Our Ref: 2023/105859
File No: R/2023/5
Your Ref: SSD 47662959

Royal Prince Alfred Hospital Redevelopment – SSD 47662959 – Advice on EIS

Thank you for your correspondence dated 1 February 2023 inviting the City of Sydney Council (the City) to comment on the proposed redevelopment of Royal Prince Alfred Hospital (RPA).

Drawing Title
**Northern Arrival
Landscape Section**

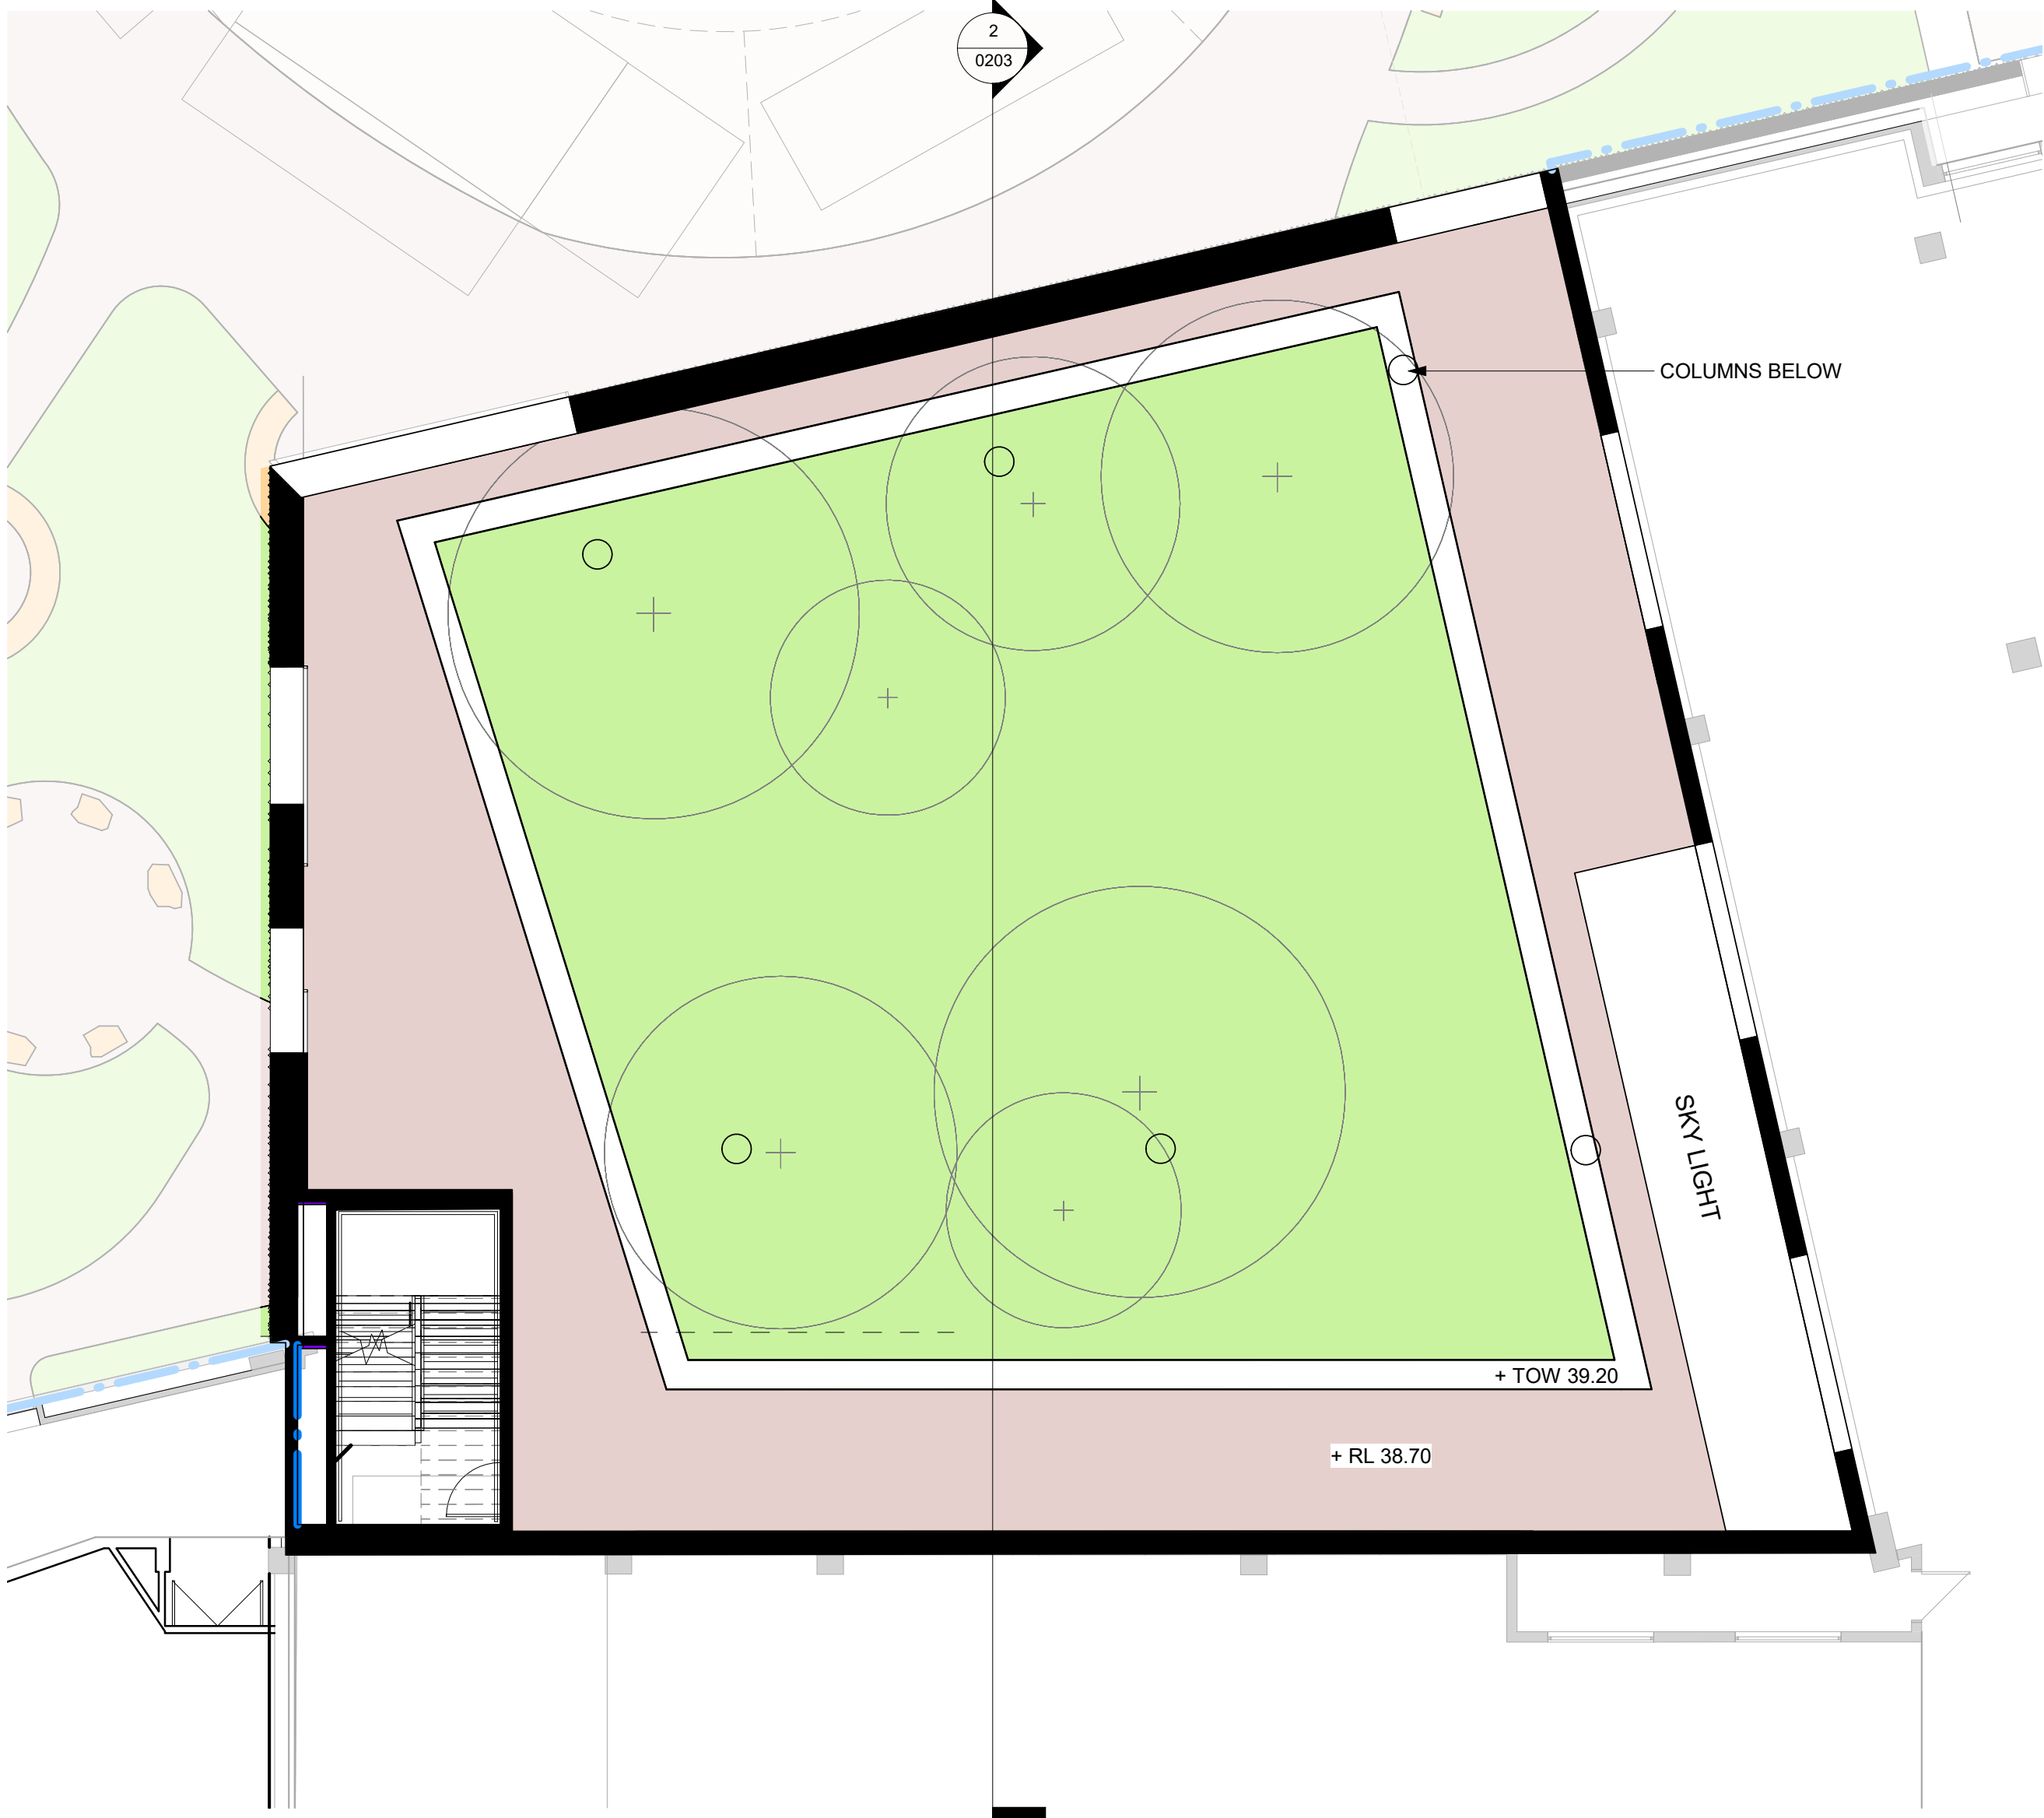
There is a conflict between the pedestrians using ramped pathways and location of parking and disabled parking spaces on the entry drop off road. This will be a heavily trafficked pedestrian space and the ramps vary between 23m wide and opening car doors may obstruct the pathways resulting in inequitable access and potential safety issues.

The design does not provide a “clear and concise public, patient and staff circulation pathways that minimise/eliminate any cross over of pathways” required of the Clinical Design Objectives. Further the parking locations do not demonstrate that, “vehicle access does not dominate the public realm, particularly on Johns Hopkins Drive” required by the Place Making and Design Objectives.

- *A review of the layout to mitigate conflicts between vehicle and pedestrian access, ensure all palm trees and seating areas minimise obstructions on the pathways is recommended.*

The proposed mix 1 planting that extends from the plaza into the entry is covered by the building awning and elsewhere the awning projects into proposed large tree planting.

- *A review of the proposed mix 1 species is recommended, and confirmation is required that confirms the species will survive in the light conditions. It is also recommended that awning details are submitted to confirm no impact on future tree canopies.*

The entry lobby includes planters entirely internal to the building with limited light levels. Landscape sections indicate low planters with integrated seating and palms with no levels (RL, TW, SSL) to confirm the design suitability.

- *The landscape design must ensure planter design makes allowance for minimum 1 metre soil depth and adequate soil volume to support the palms to maturity. Planter seating must be wall mounted with armrests in a hospital environment and all plant species are selected to thrive in the available light levels and microclimate to provide biophilic benefits to patients and workers.*

Drawing Title
Northern Terrace

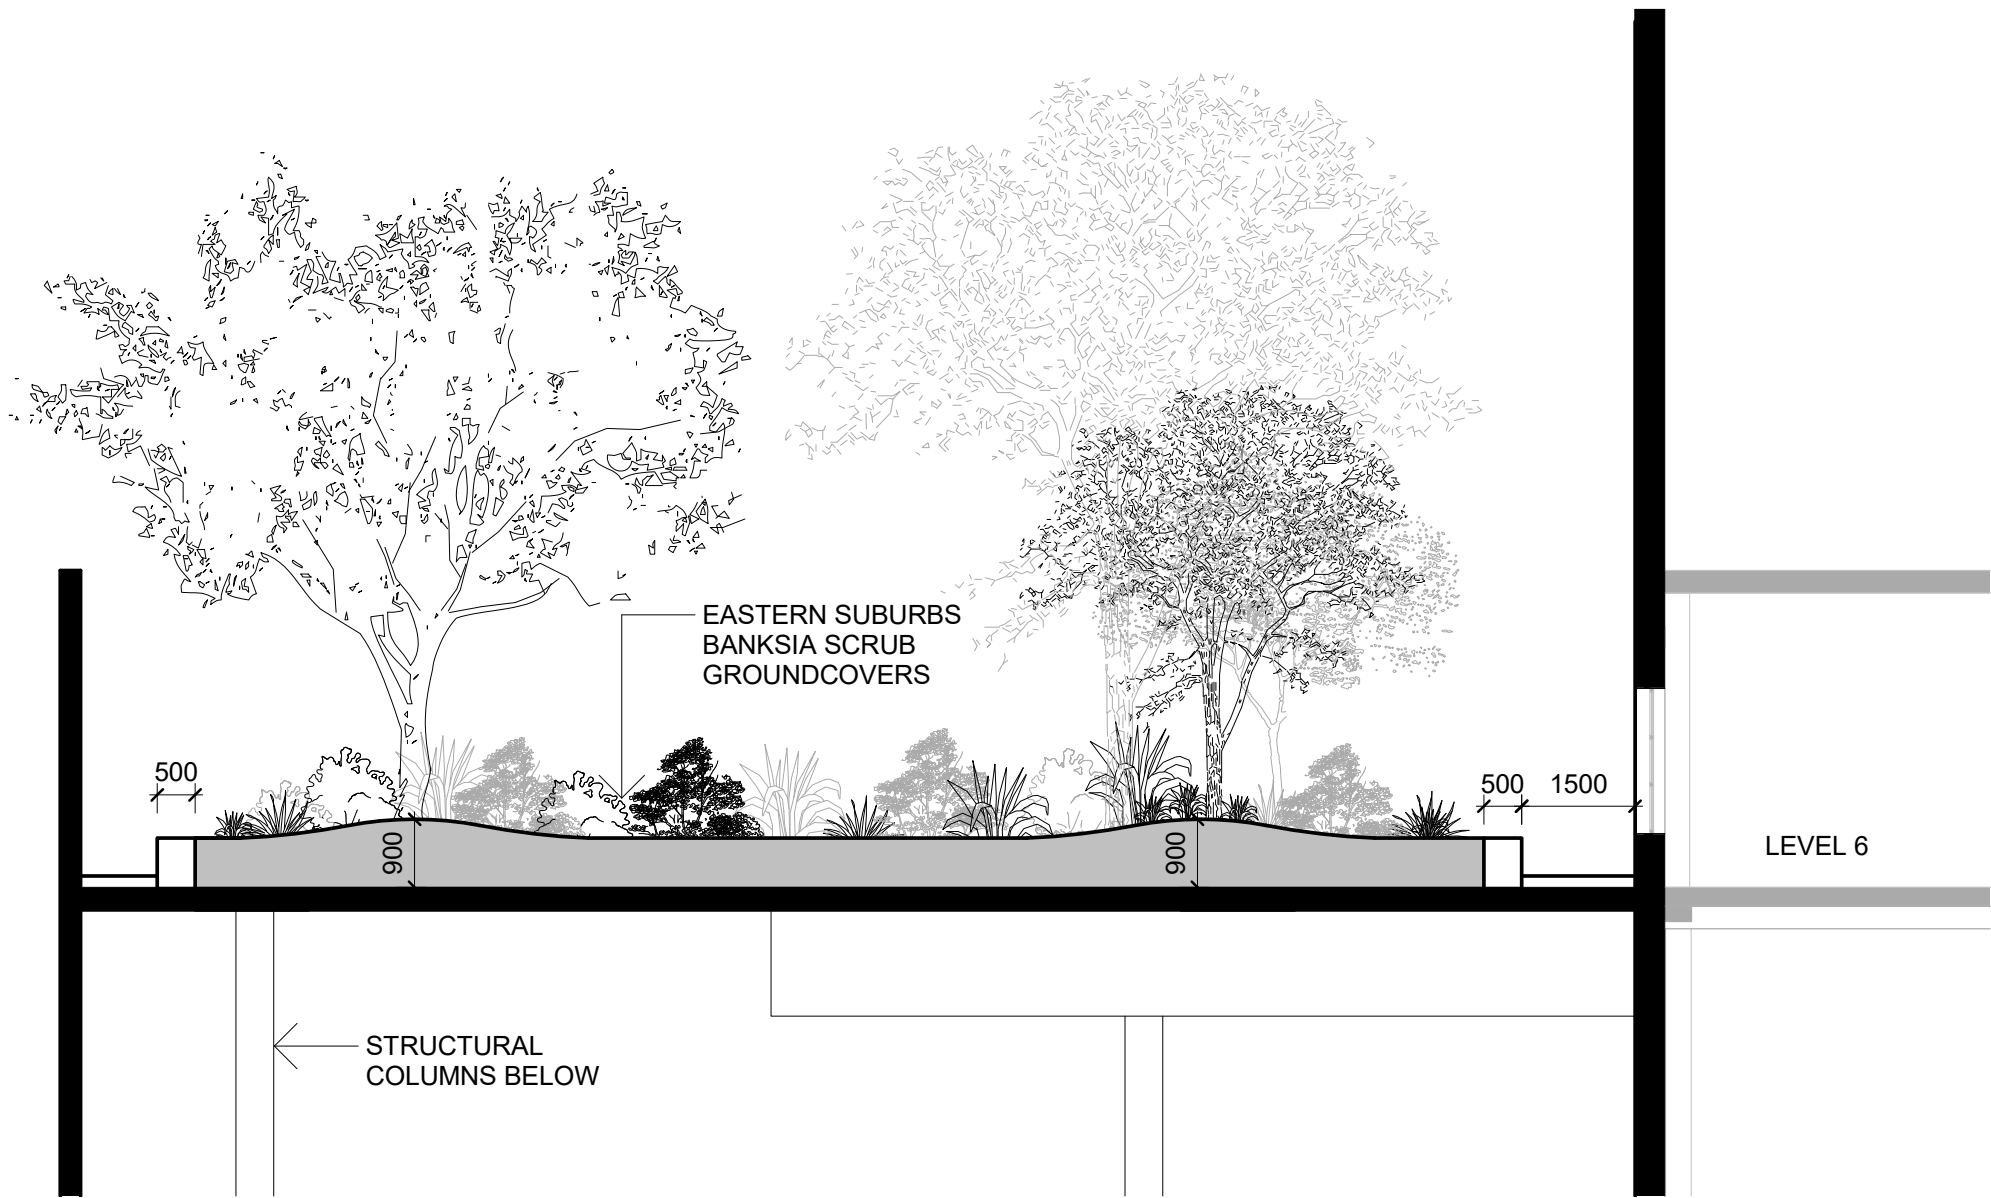
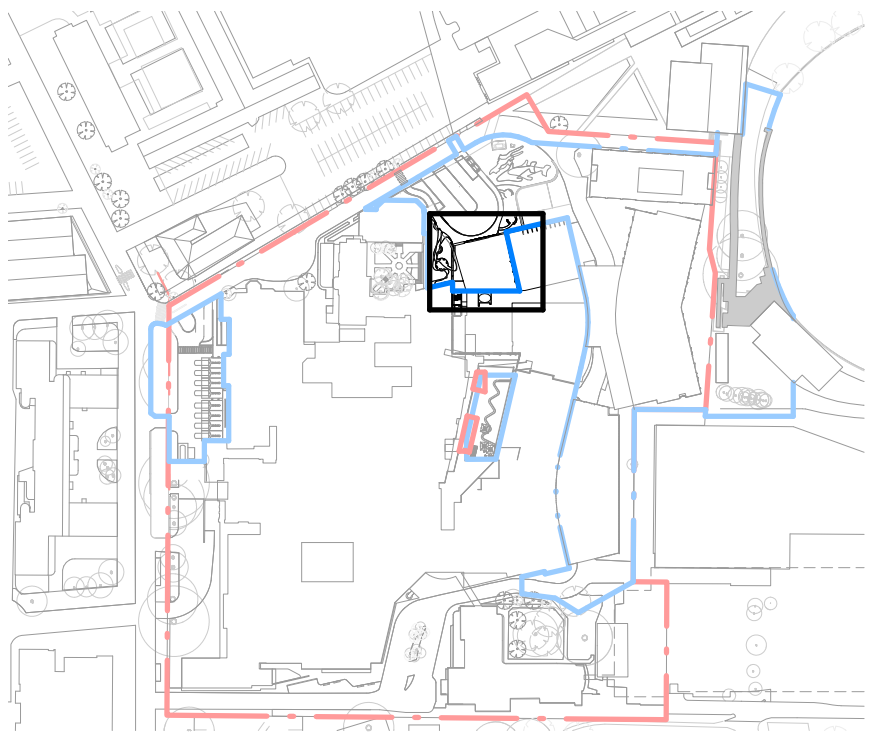
The accessible green roof with small sized trees includes a perimeter path to the edge for usability.

The green roof design includes a low seating wall 500mm high with mounding up to 400mm to achieve 900mm. This is not a supported design outcome for a new development and planting is unlikely to thrive or meet the required canopy targets. Soil is organic and subsides over time, which can result in bare root balls and plant failure. Mounding up to maximum 200mm is acceptable at installation.

USYD Planting Plan

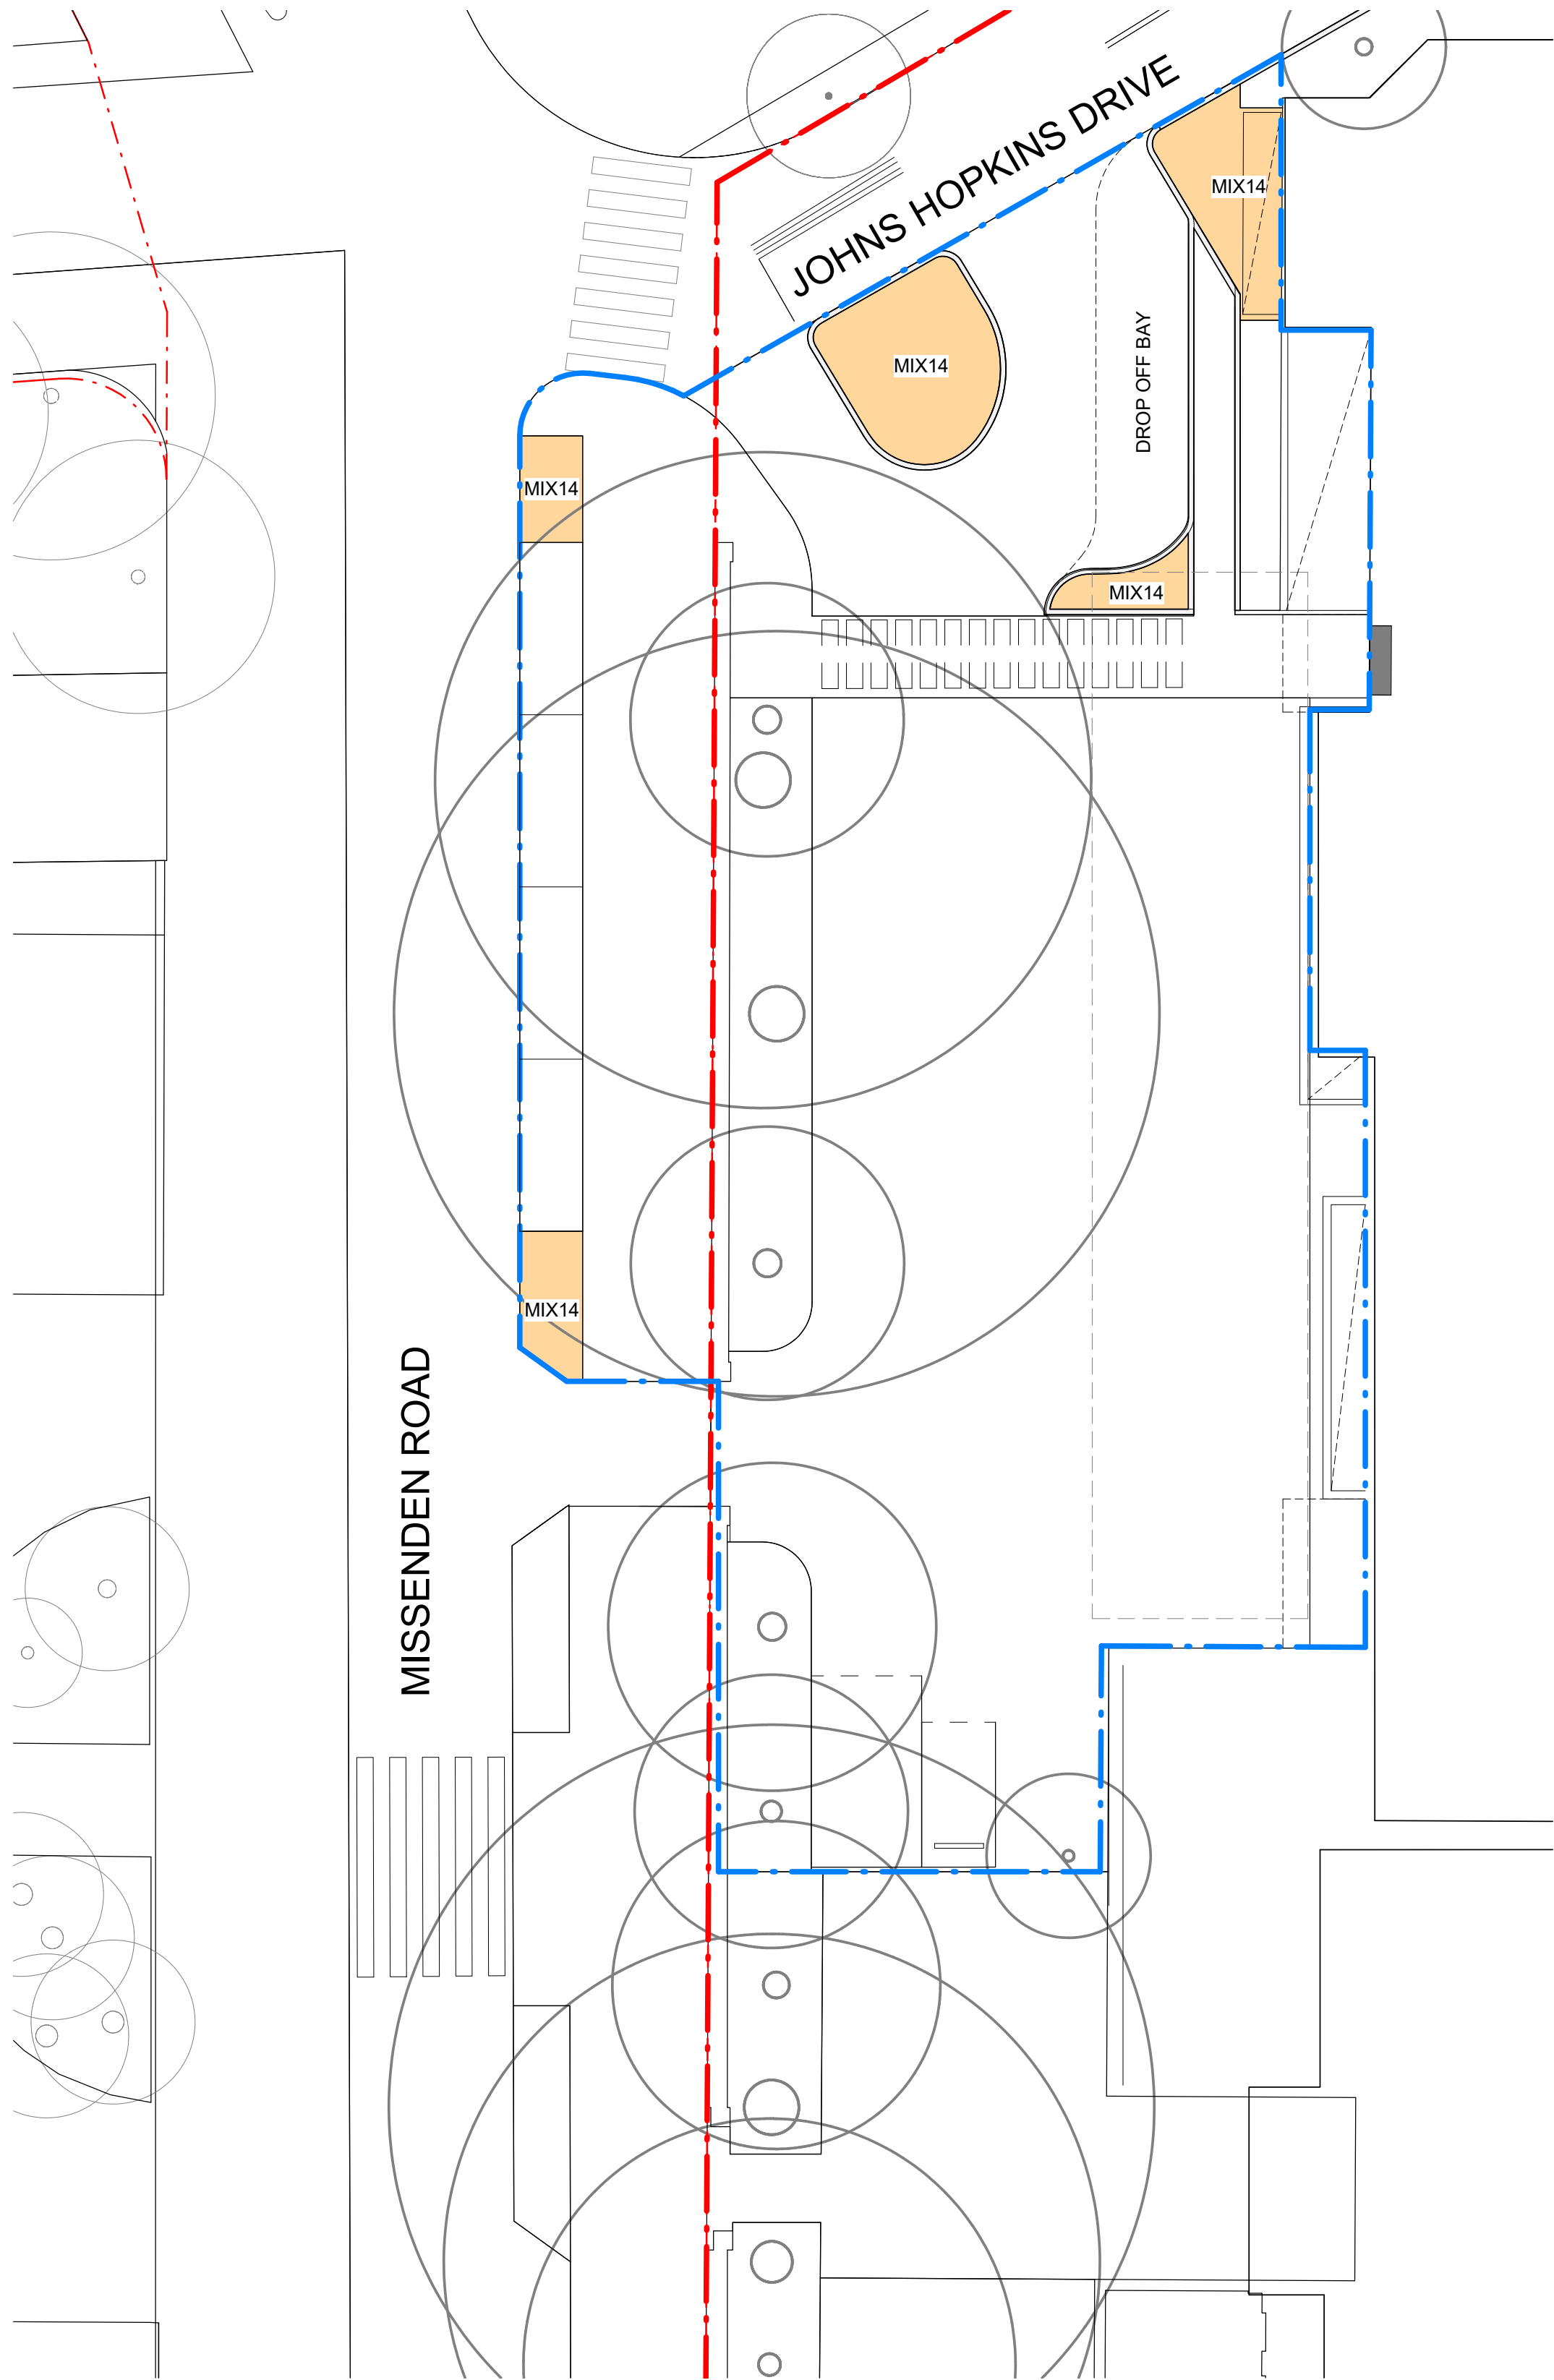
According to the proposed landscaping for the site there is a total of 88 new trees to be planted. Nine of these trees are proposed to be planted within the University of Sydney campus grounds around the western edge of Oval No 1 as part of the Tree Replantation Strategy.

Considering the City notes the removal of 15 significant trees within the Rear Garden precinct that should be retained and protected, the planting of the nine trees as part the Tree Replantation Strategy as replacements within the grounds of the University is not supported. These nine trees should be relocated within the RPA hospital grounds to provide increased canopy coverage to the design and increased screening of the proposed East Wing Building.
